The East End School
Community Gardens
Loring Memorial Park

Sheridan Street Mews

DRAWING NO. **C-10**

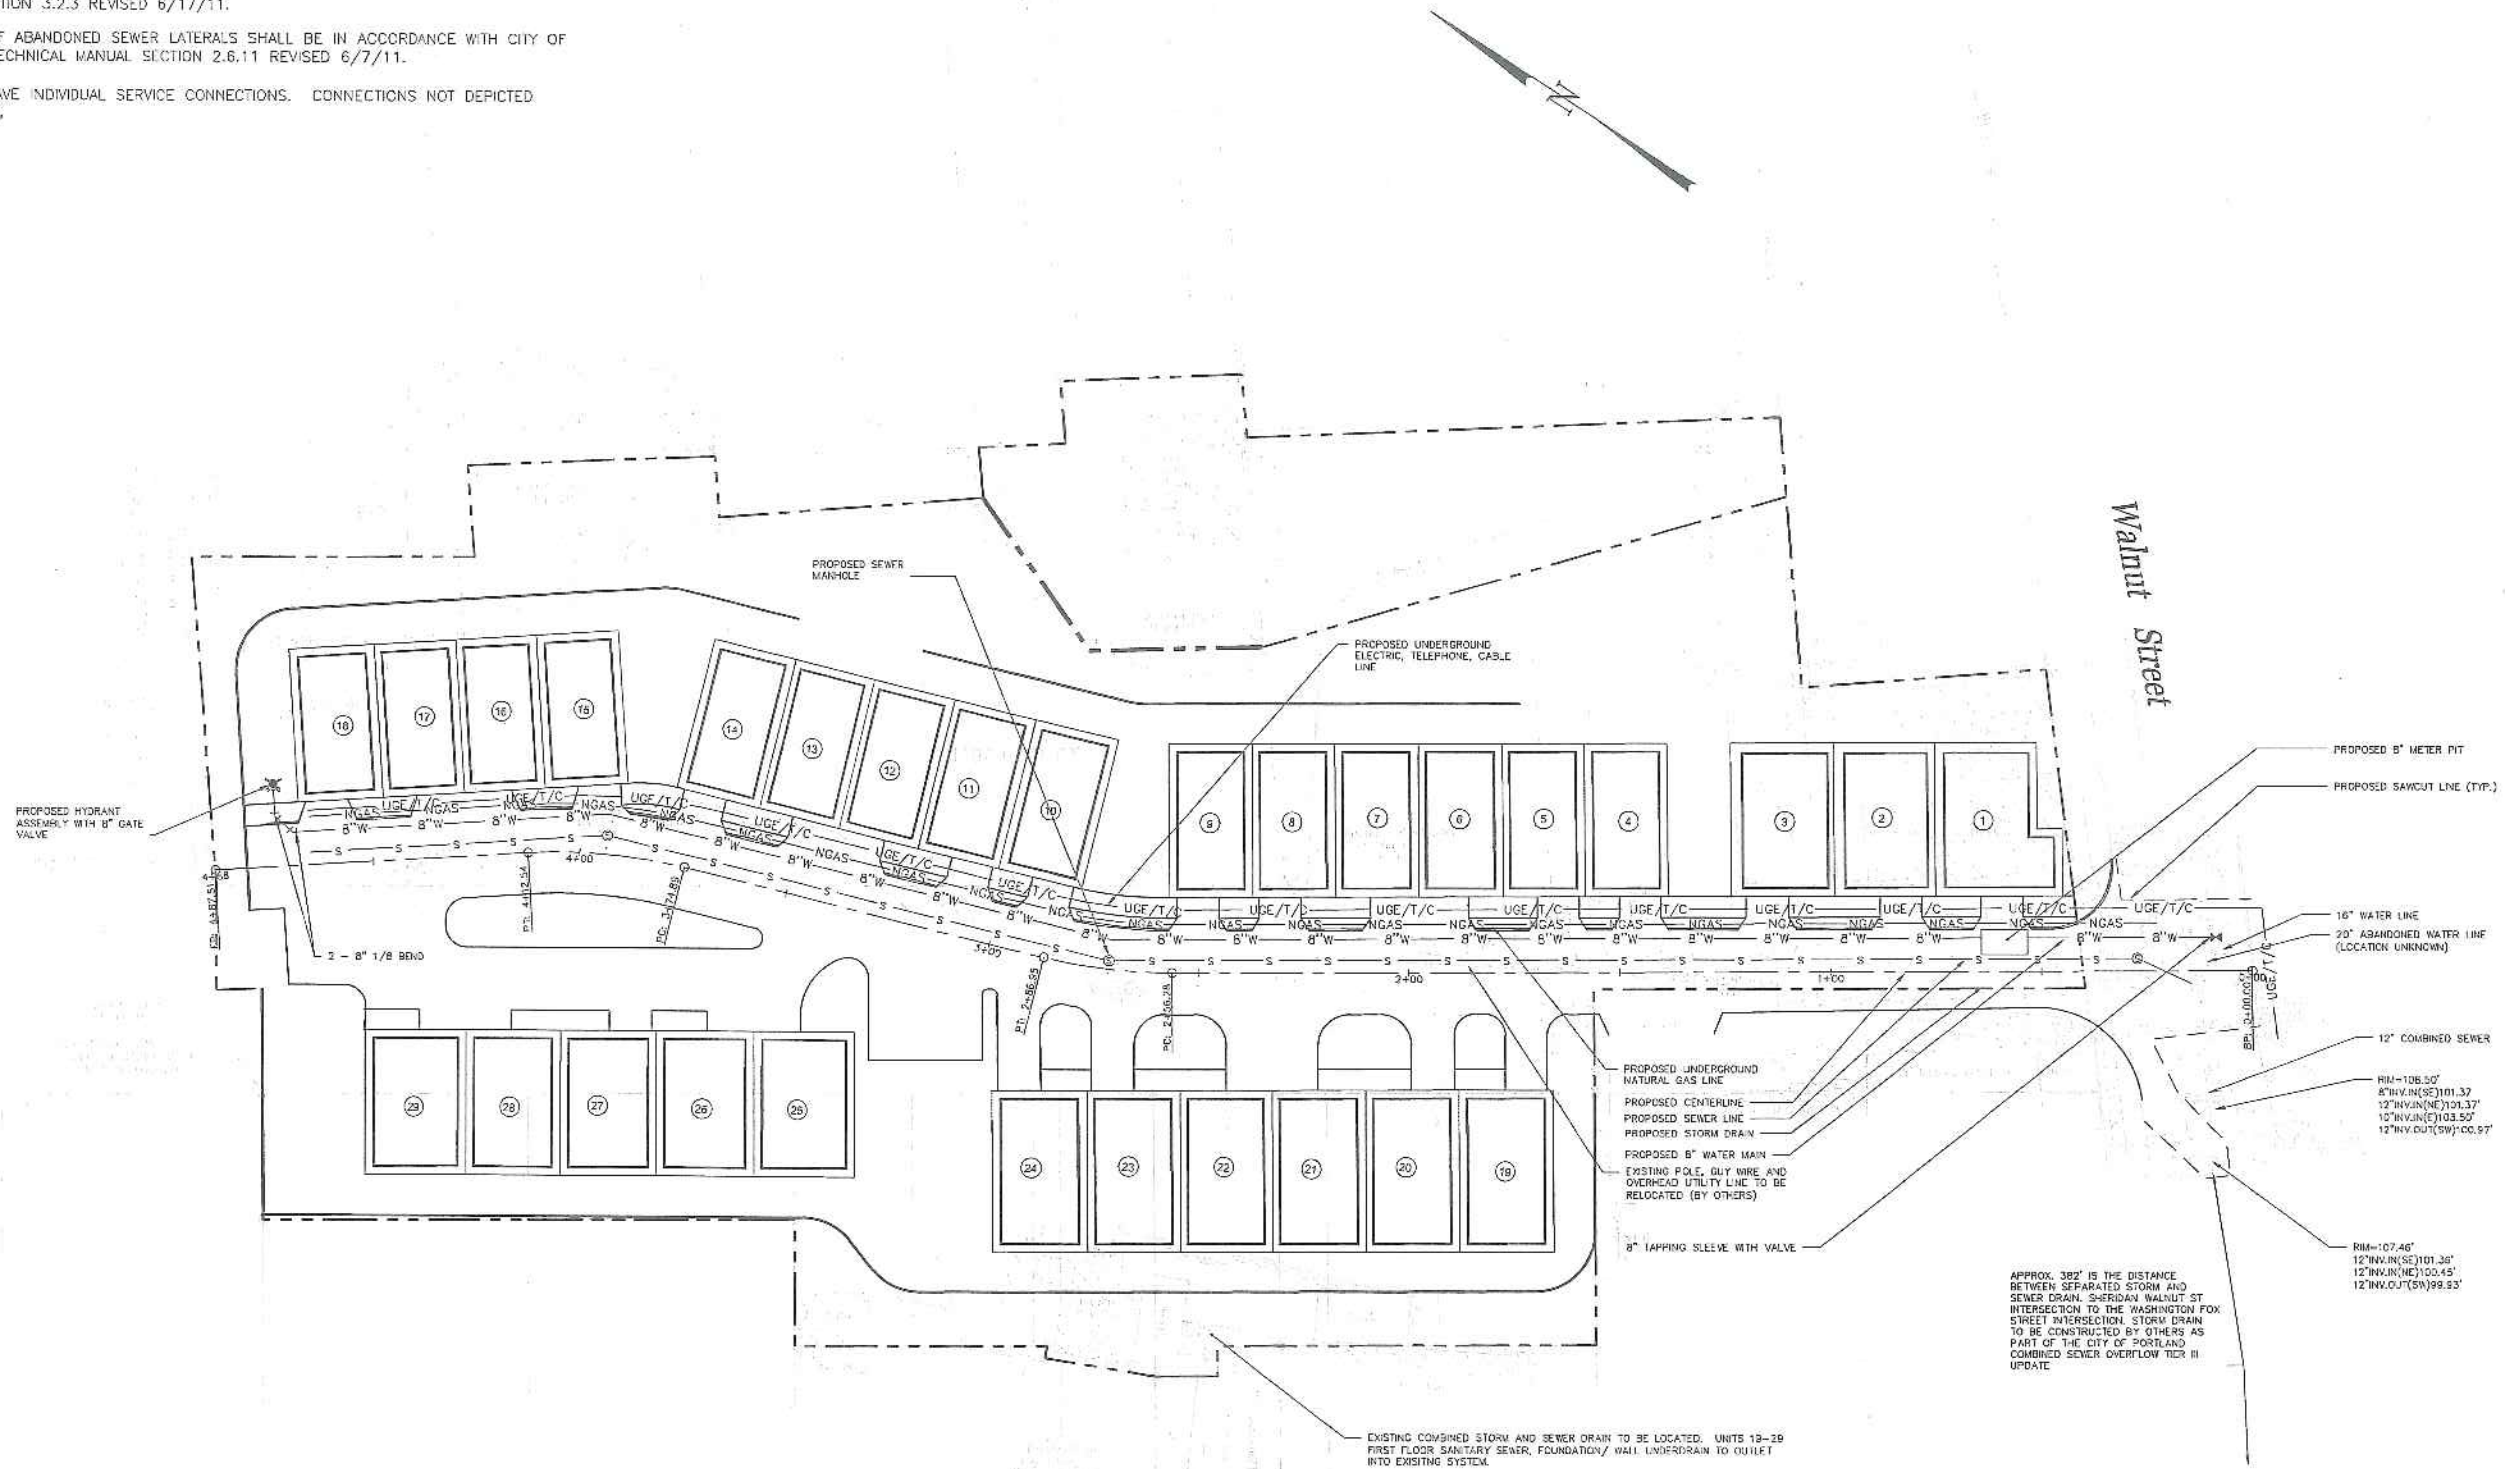
D The western segment of Jack Footpath should be upgraded to a multi-use trail connection, and more in keeping with the new mews through Munjoy Heights. It should be 8' wide and paved to facilitate ADA & year-round use, or at minimum be hard-packed like the Back Cove trail.

The city should retain its public street ROW's. Encroachment of buildings into the ROW should be avoided.

A&B Sheridan Street through Munjoy Heights should be developed as a modern mews, complete with attractive paving, and both fixed & moveable plantings and furniture.
The planned sidewalk is not needed. Even in its current configuration it would go unused, crossing directly in front of garage and front doors. Separation of uses in this context is inappropriate.

C The top of Cove Street should be connected to the Sheridan Street Mews with a staircase. The proposed six unit building could be split into two three unit buildings to make room for the Cove Street Stairs.
